Subject: RE: Please find attached amendment on planning application Ref: F/30/18/PL

Engineers Further Comments Regarding Surface Water Drainage

APPLICATION NO: F/30/18/PL

Description of Works: 2 multispans tunnels, 2 ancillary outbuildings, drainage pond, associated drainage works, external hardstanding for vehicle parking, access and turning.

Title
CONSTRUCTION DETAILS

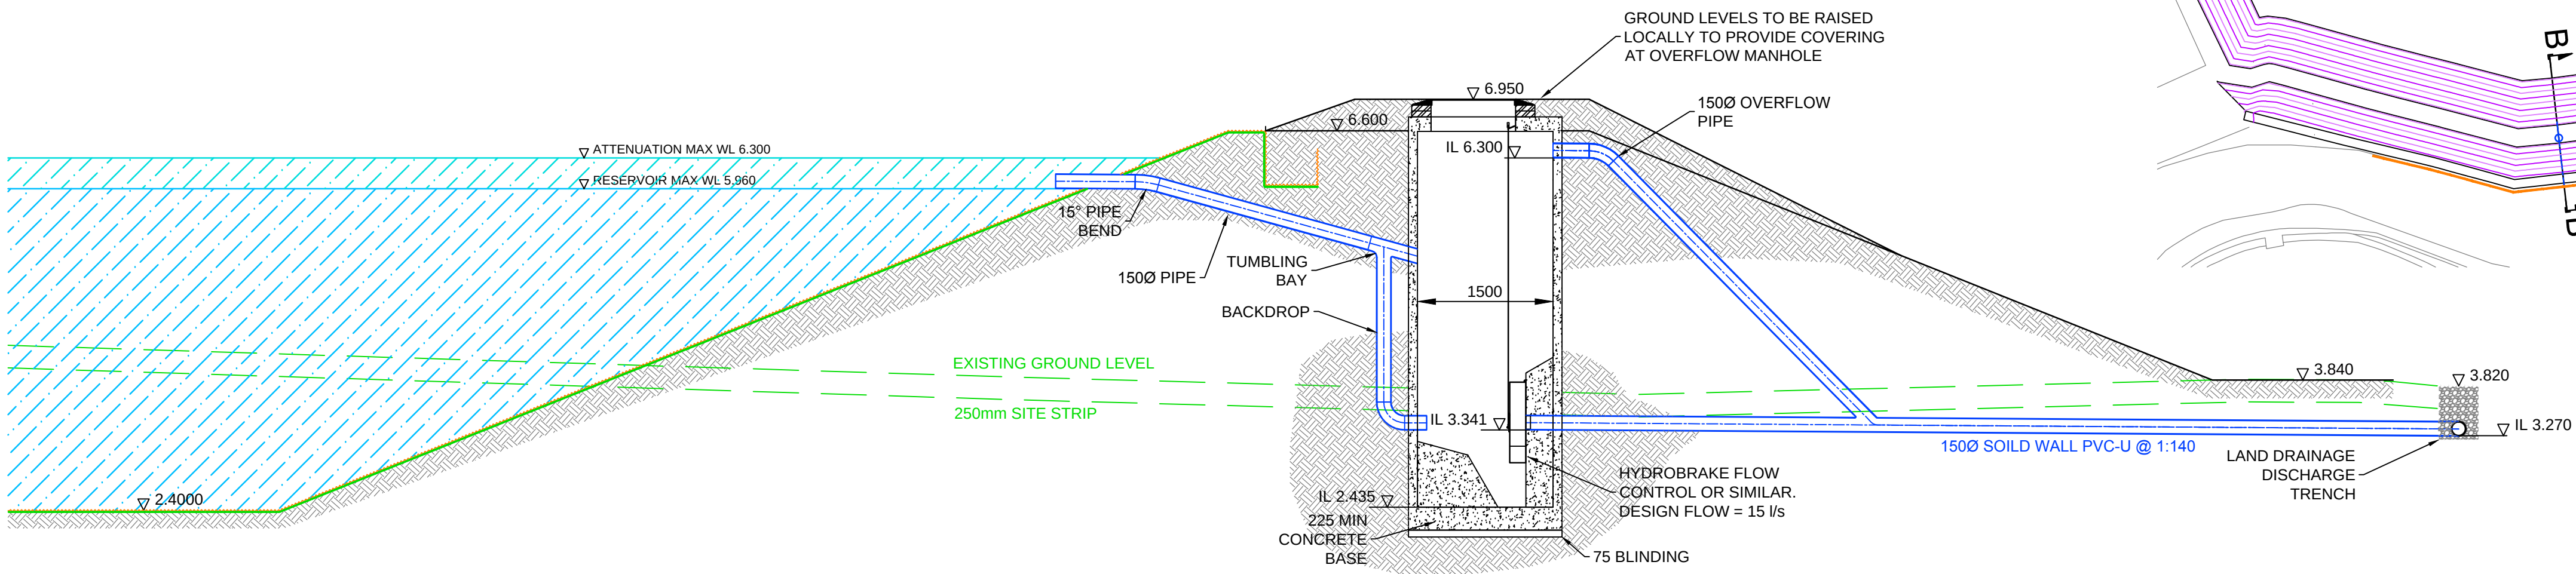
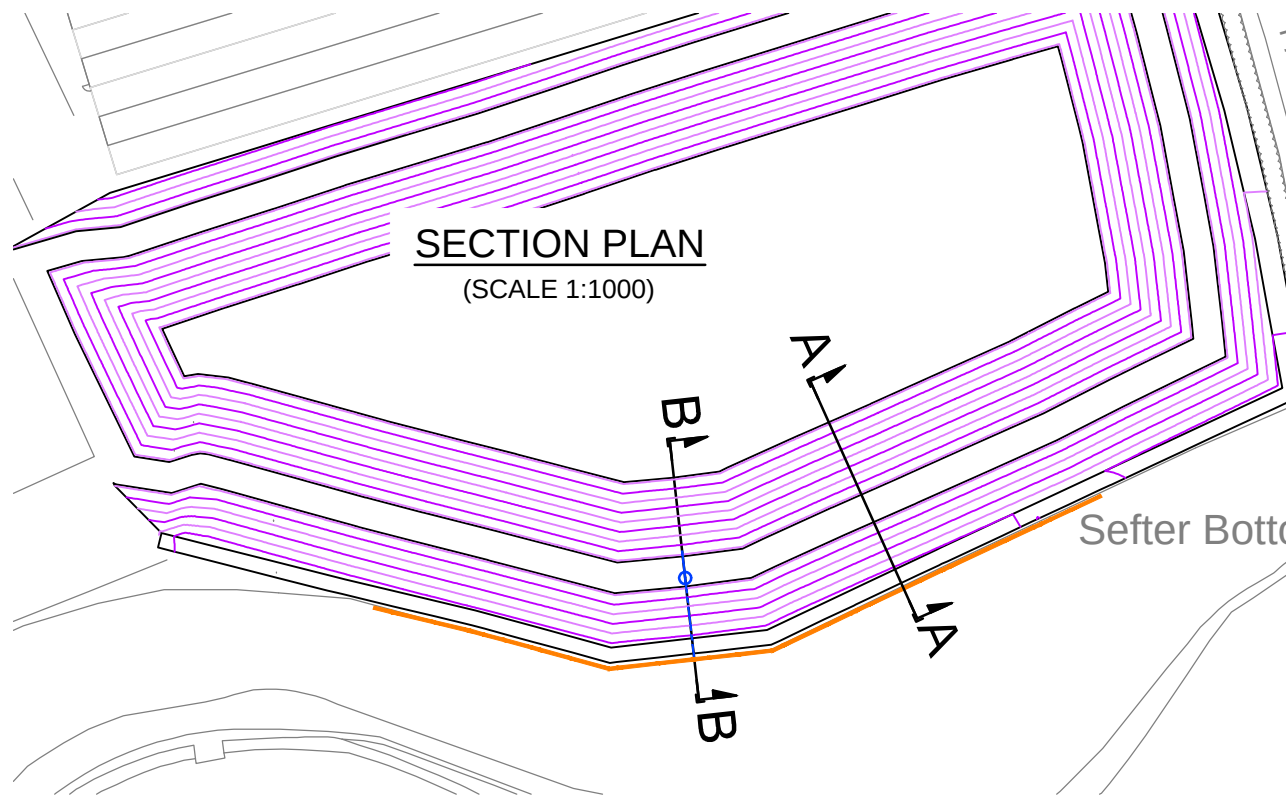
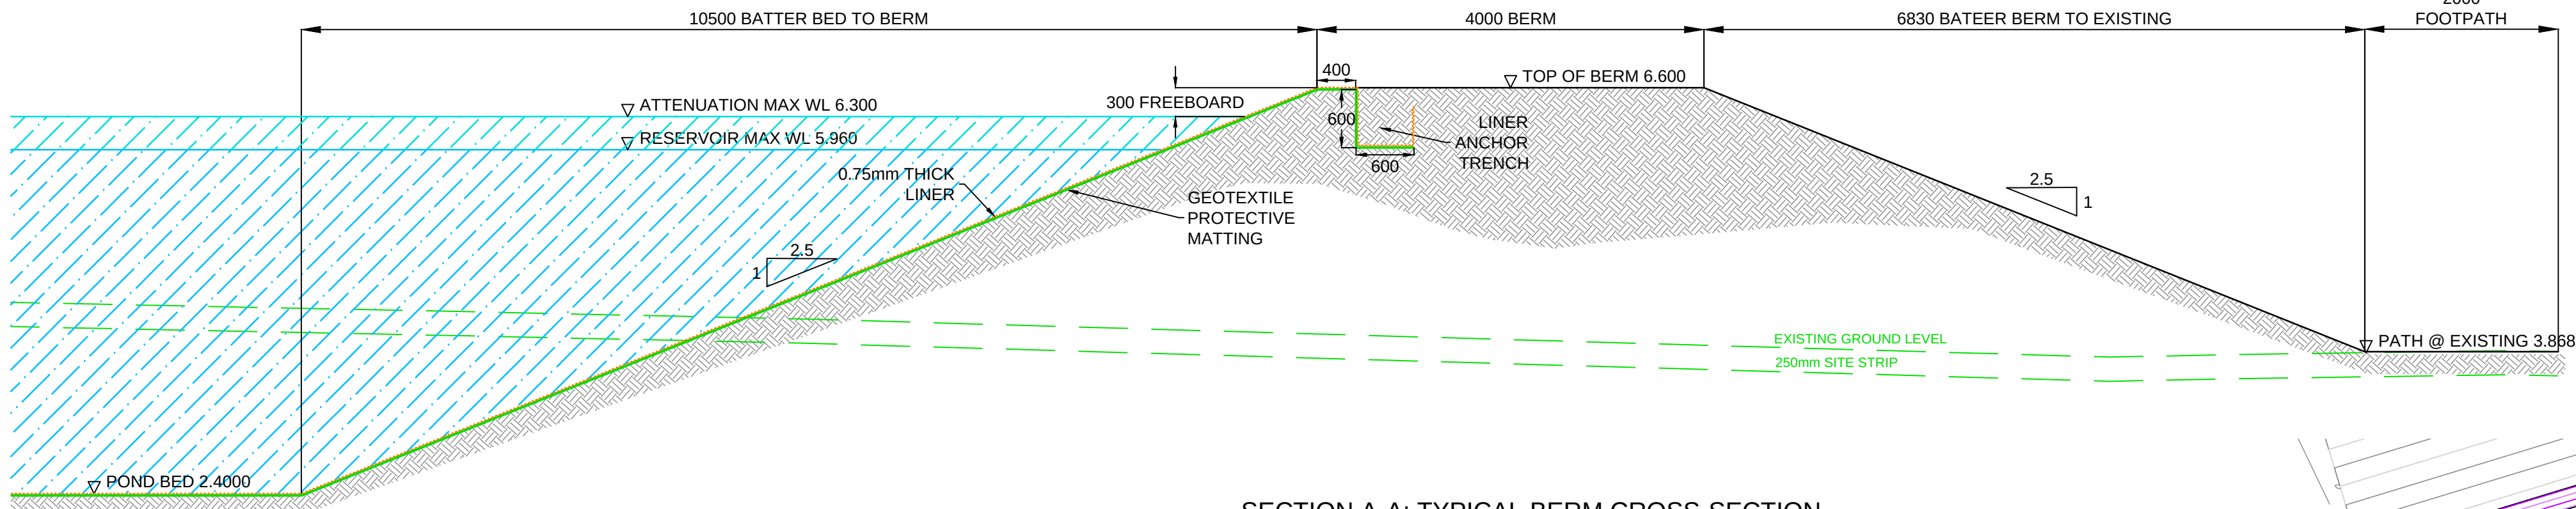
The reservoir construction details drawing shows that the reservoir will have an overflow restricted to 15l/s draining into a land drain. This is not what has been stated elsewhere, which is that the overflow will connect into the ditch. This connection should be via solid pipe means. Drainage details need to be agreed once infiltration testing and groundwater monitoring has been completed. Therefore, please do not approve this plan or ensure that the specific drainage details can be altered.
